**Our ref:** AN/2023/135033/01-L01  
**Your ref:** EN070008  
**Date:** 11 January 2023

**Application by Chrysaor Production (UK) Limited for a Development Consent Order (“DCO”) for a 55km underground pipeline for the transport of Carbon Dioxide from the Immingham industrial area to offshore storage – the Viking CCS Pipeline (“the Proposed Development”)**

- 2.2 We have reviewed the Development Consent Order (DCO) application, Environmental Statement (ES) and supporting documents submitted as part of the above-mentioned application, following notification of its acceptance for Examination on 22 November 2023. Our comments below are presented using the document references and ES Chapter headings relevant to our remit.

4.14 Washingdales Lane Block Valve Station Plan and Elevations

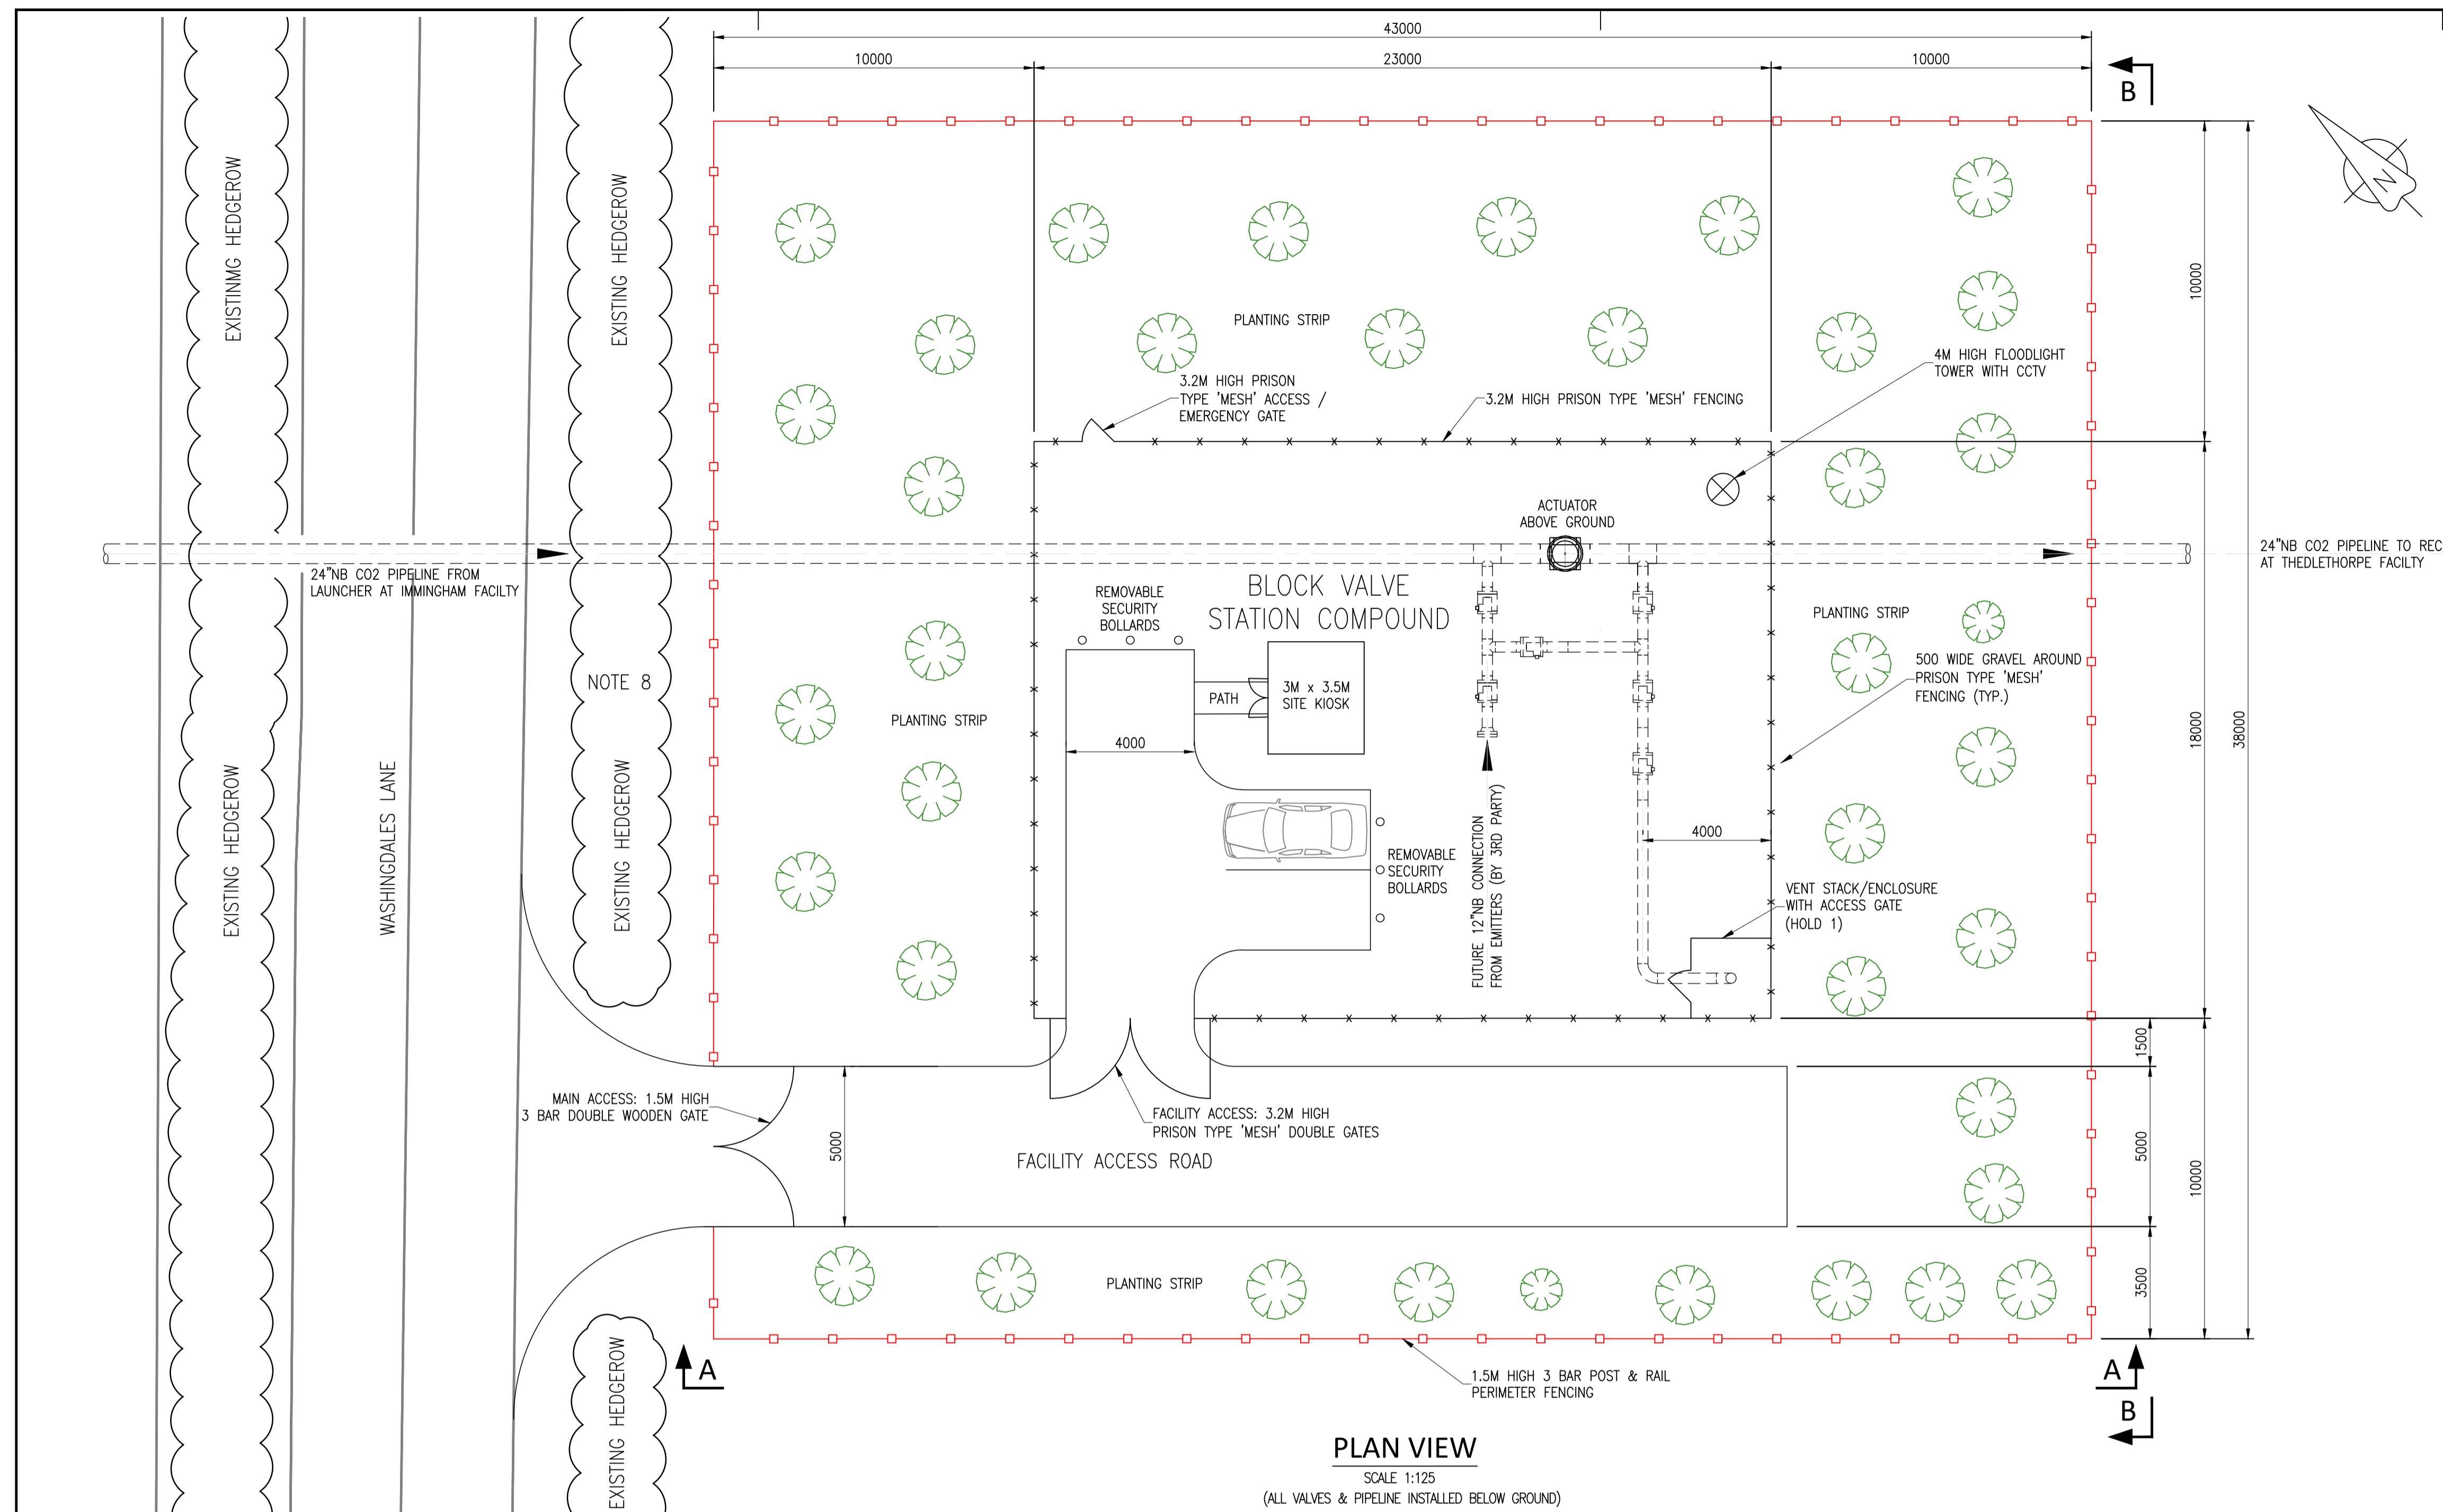
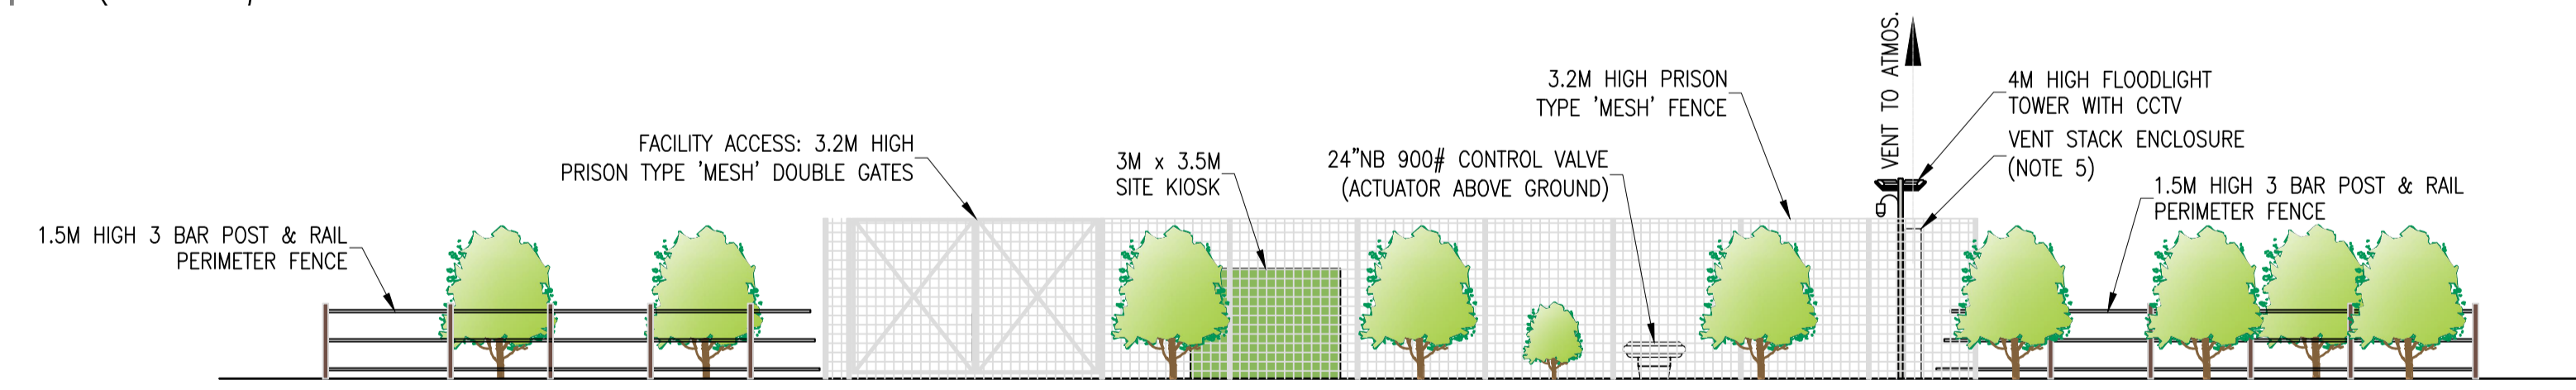
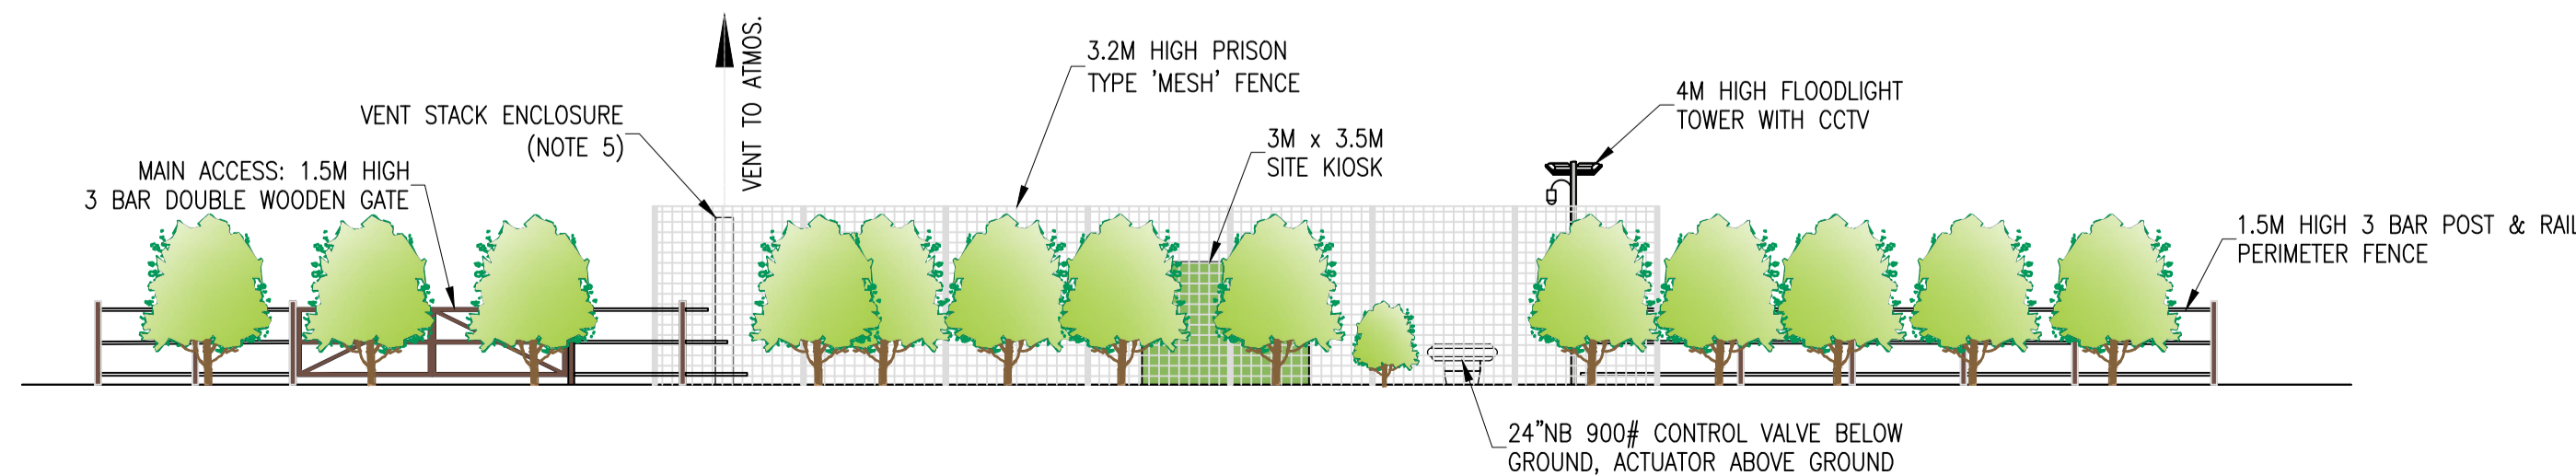
- 8.23 **6.4.11.3 Appendix 11-3: Drainage Strategy [APP-099]**  
 Sections 3.1.14 and 3.2.7 describe the preference for infiltration drainage of surface water at Washingdales Lane block valve station only. We would highlight that this must not include drainage of areas subject to contamination, and must be designed in line with best practice.
